From: Martyn White <Martyn.White@arun.gov.uk>
Sent: 24 August 2020 15:00
To: Amber Willard <Amber.Willard@arun.gov.uk>
Subject: BN/62/20/HH

BN/62/20/HH

Construction of a garage space and Gardener's Shed

drawing: PROPOSED GARAGE PLANS, SECTION AND ELEVATIONS

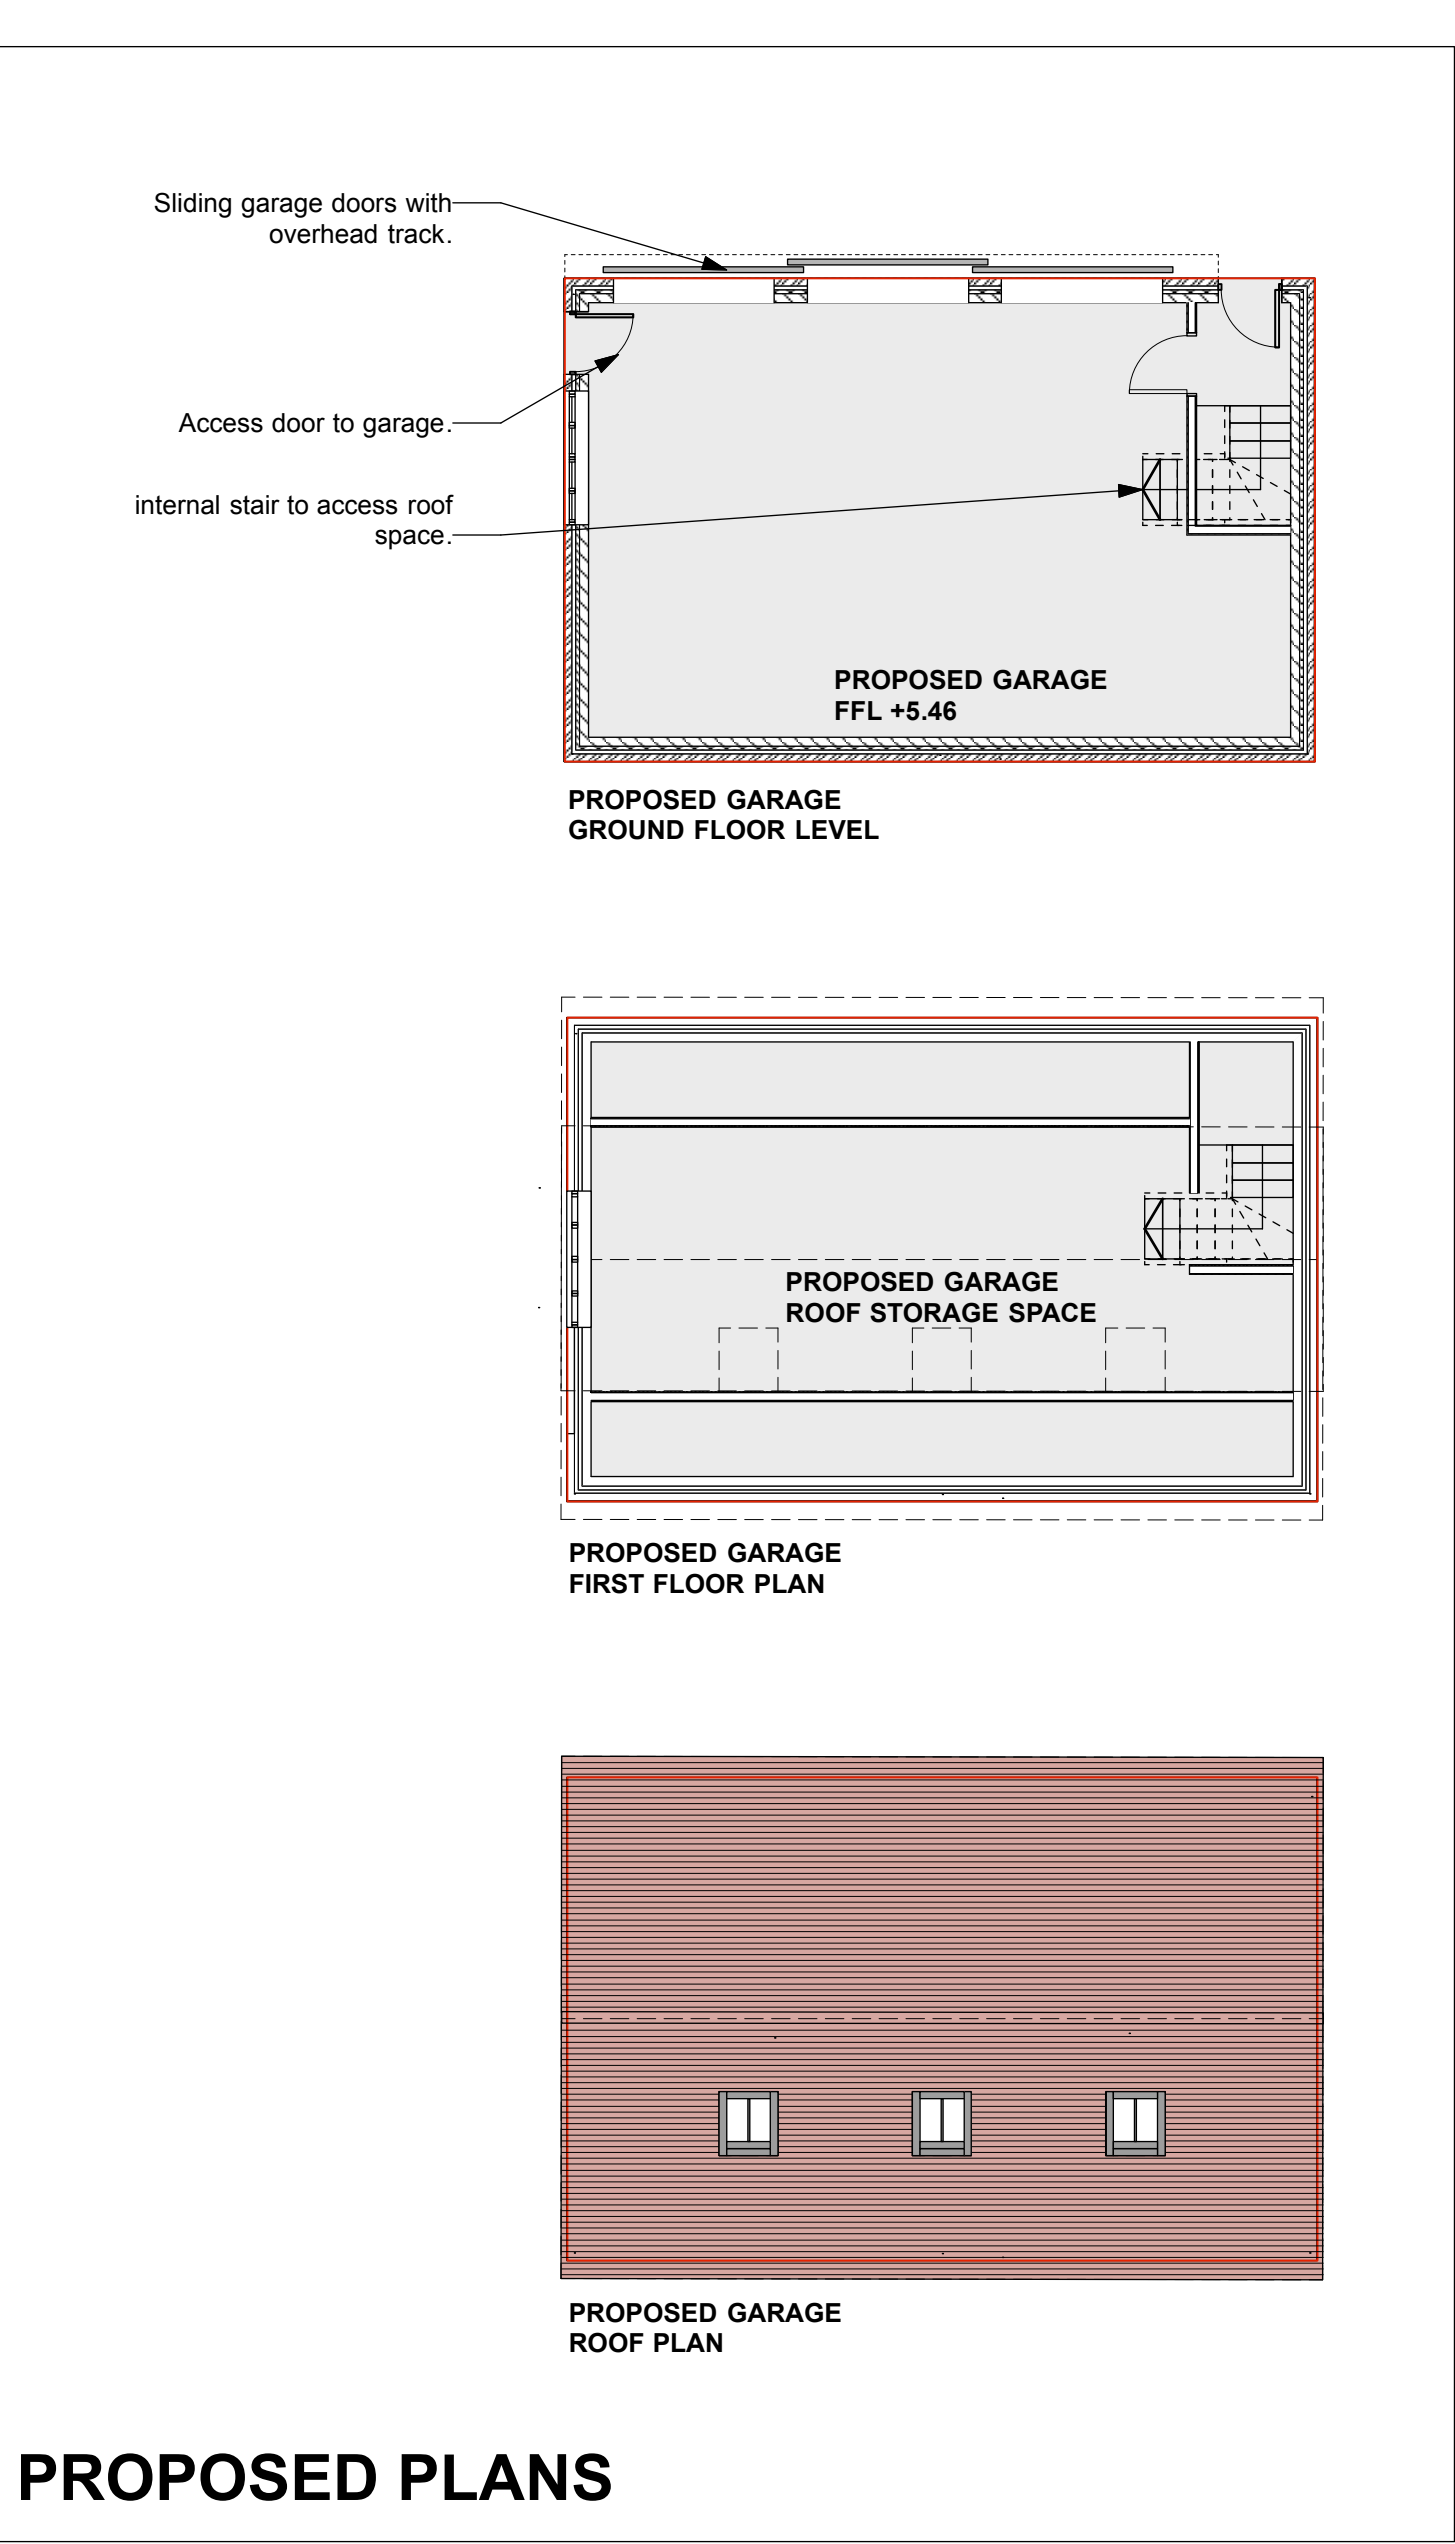
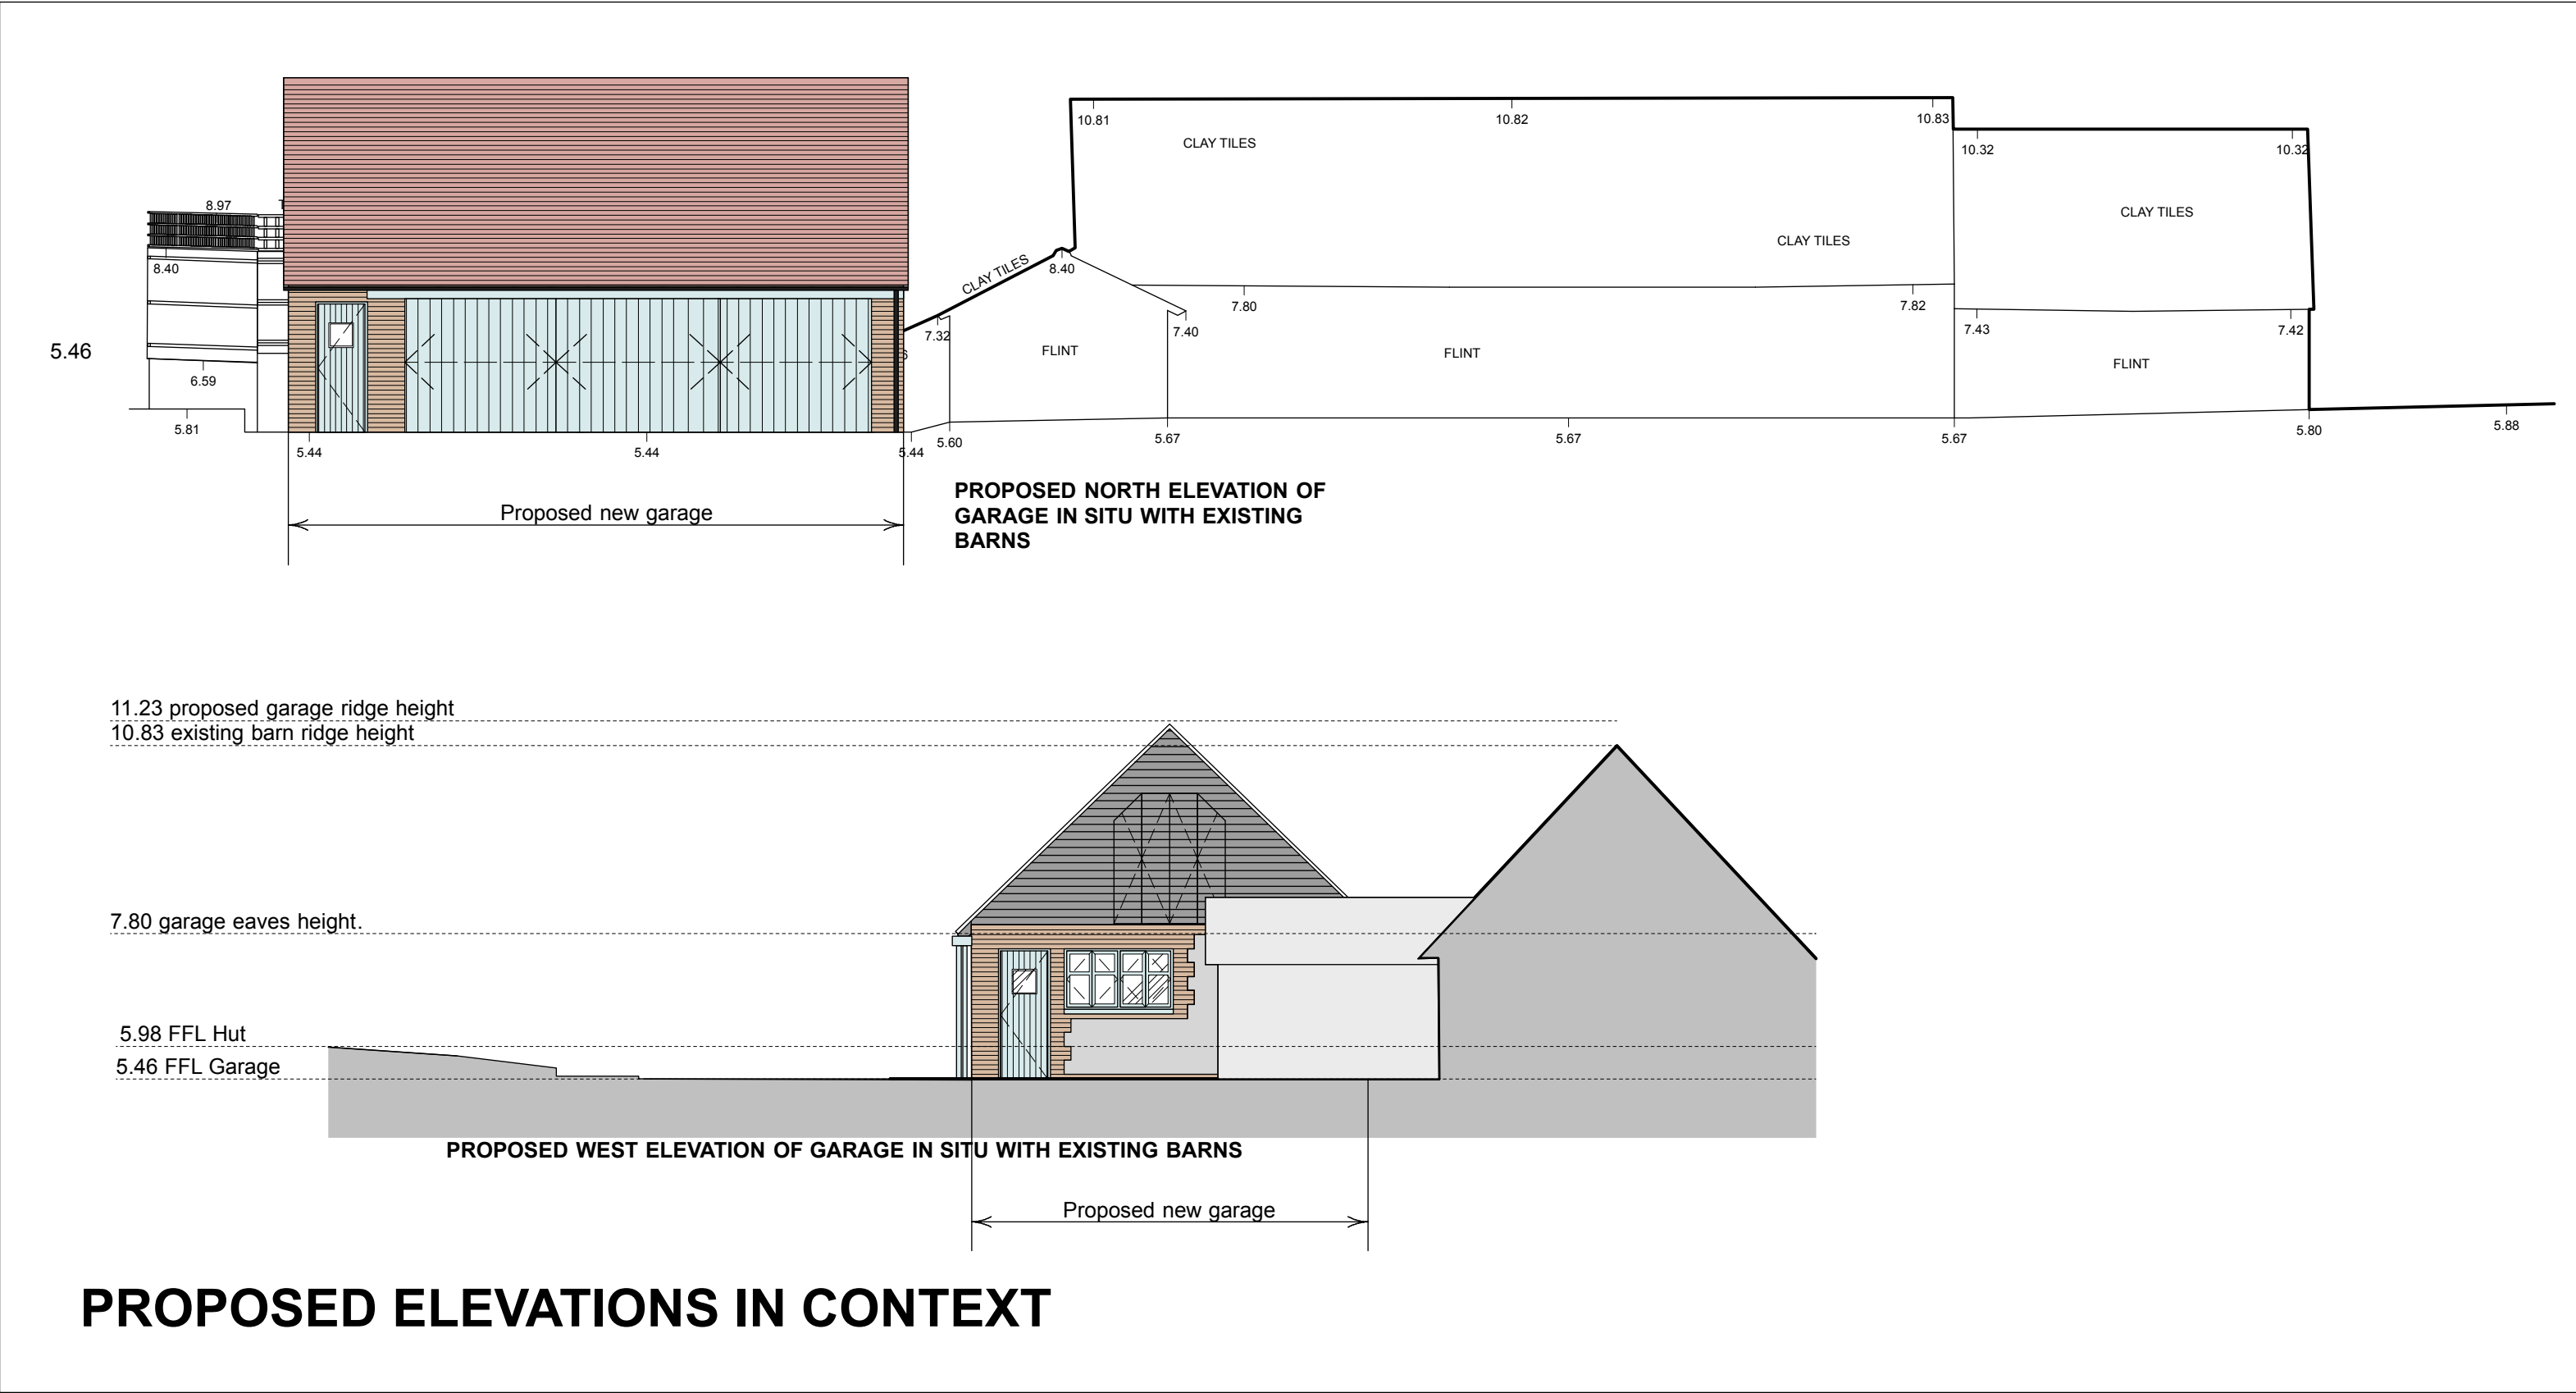
These have a traditional character to them; they appear to have taken reference points from elements of the application site as well as the adjoining former agricultural buildings. Further, they are also of a scale which would reflect the existing former agricultural buildings and would sit acceptably in their location when viewed from other parts of the application site.

Whilst located in close proximity to the listed church, it is suggested that as they reflect the neighbouring buildings, they would form a natural extension to the existing former agricultural building group and not necessarily a new insertion. It is considered that the proposal will not harm the strong relationship between Barnham Court, the parish Church and the farm. Therefore, on balance, they will be acceptable. This is subject to the use of high-quality materials and craftsmanship of any proposed works.
